Our ref: OUT26/3087

Subject: Hunter Transmission Project (SSI-70610456) – Response to Submissions and Amendment Report

Detailed advice to DPHI Planning & Assessment regarding the Hunter Transmission Project (SSI-70610456) – RTS and Amendment Report

Hebden Road
BAL 10 set back

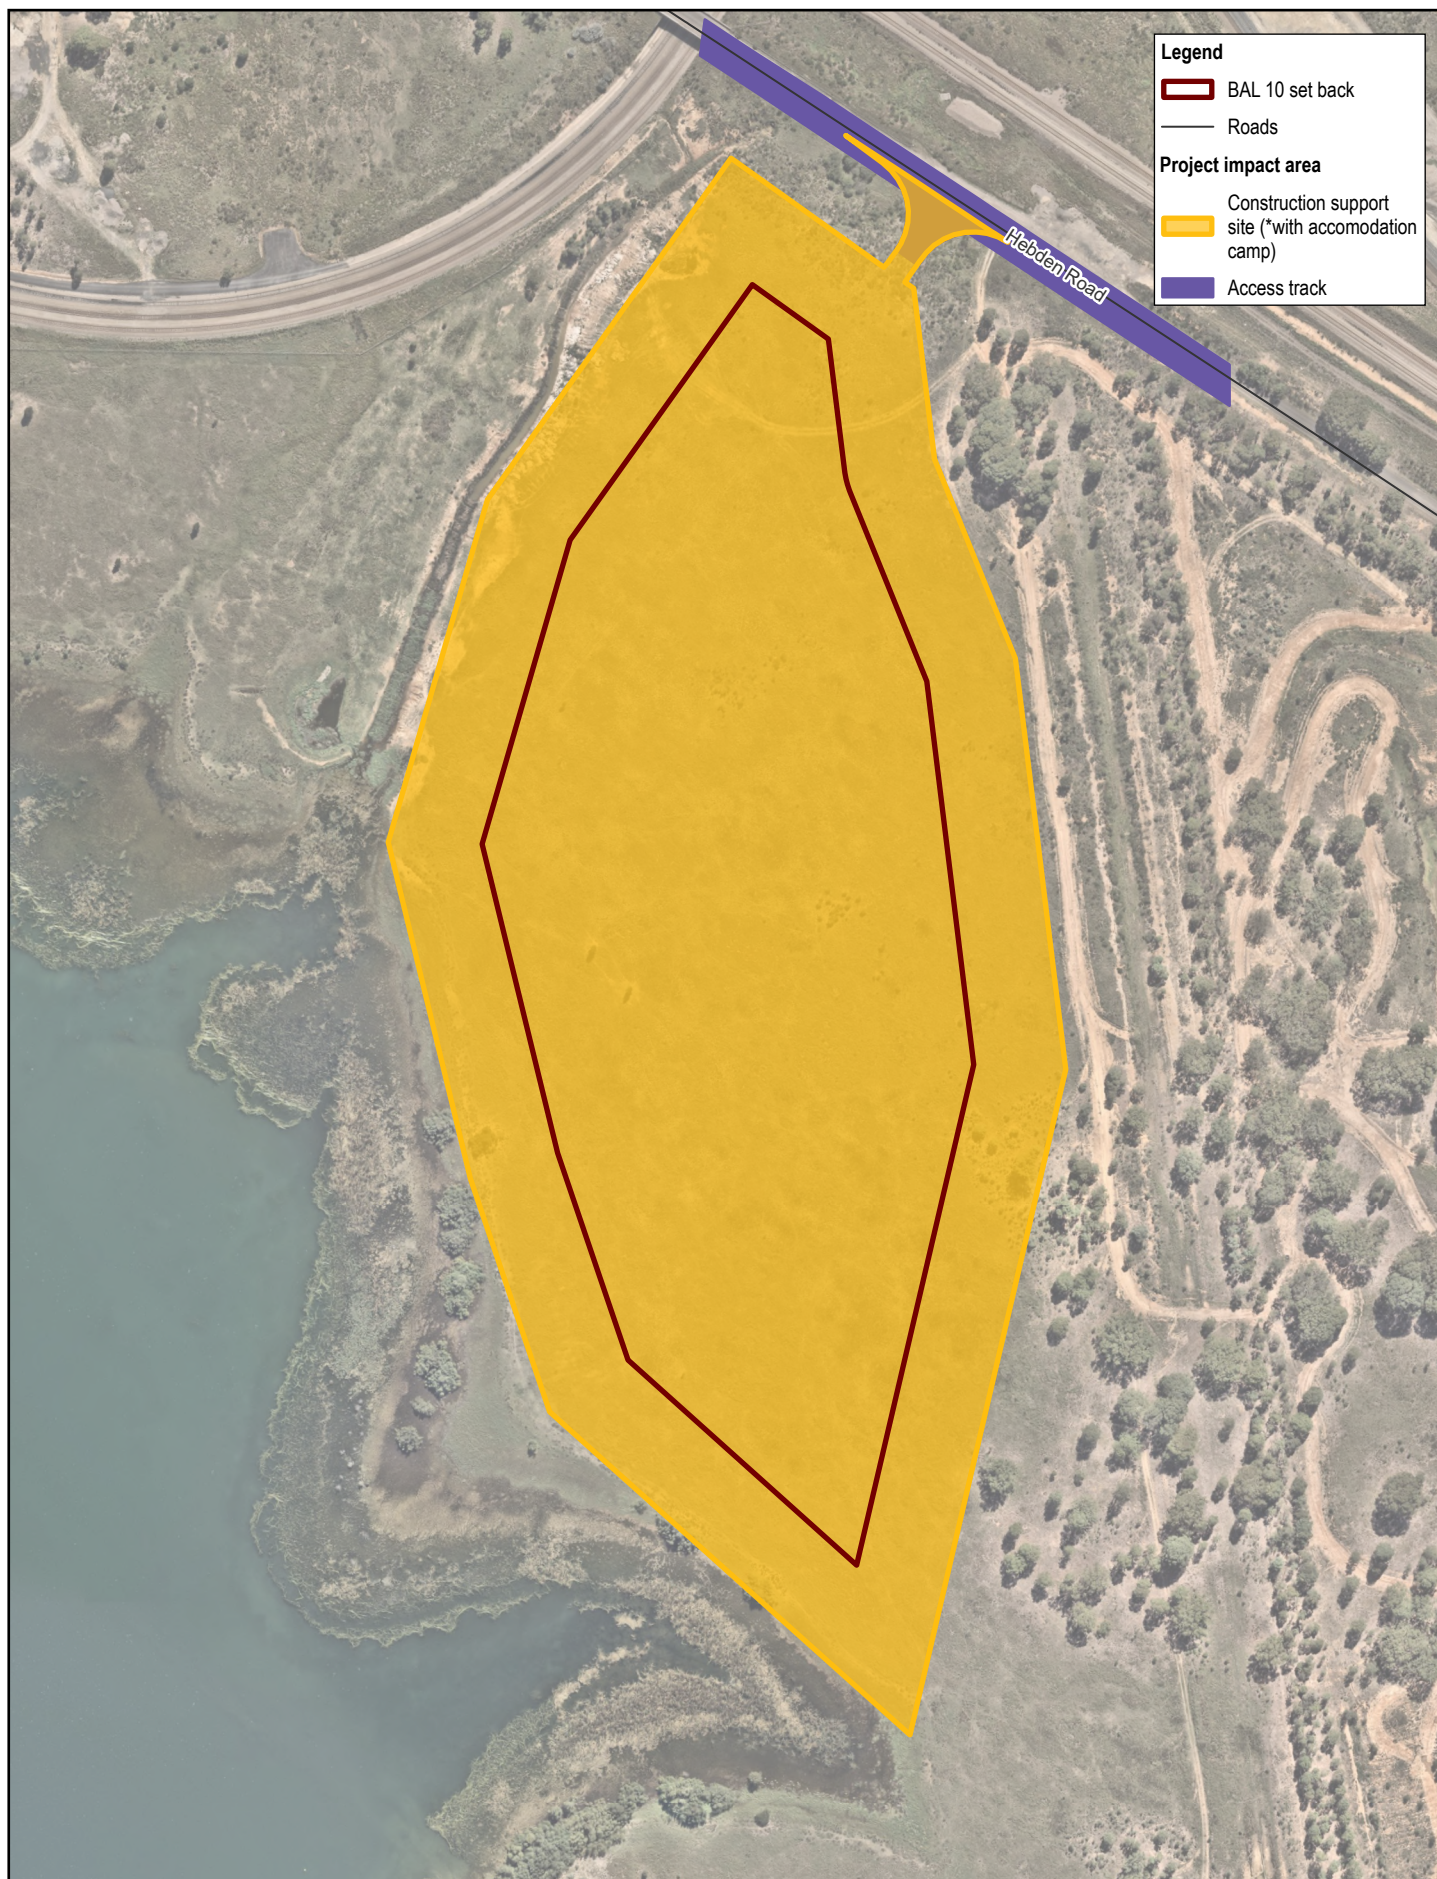
The Department of Planning, Housing and Infrastructure (DPHI) requests the proponent to amend the footprints of the construction support sites at Hebden Road, Wollombi Road and Freeman's Drive (including Bushfire Asset Protection Zones) to address the Vegetated Riparian Zone requirements of the Guidelines for Controlled Activities on Waterfront Land (DCCEEW 2025). This amendment is to:

- Ensure the retention and protection of existing riparian vegetation, including removal of all development (including APZ's) from the inner VRZ of Jigadee Ck, Cudgewai Ck and Lake Liddell.
- Include riparian offsets for any encroachment into the outer VRZs of Jigadee Ck and Cudgewai Ck.

The proposed development footprints of the construction support sites at Hebden Road, Wollombi Road and Freemans Drive, when Bushfire Asset Protection zones are considered, encroach into the required inner Vegetated Riparian Zone widths of the adjacent watercourses and lake (Lake Liddel, Cudgewai Creek and Jigadee Creek respectively) and are therefore not in accordance with the Guidelines for Controlled Activities on Waterfront Land (DCCEEW 2025).
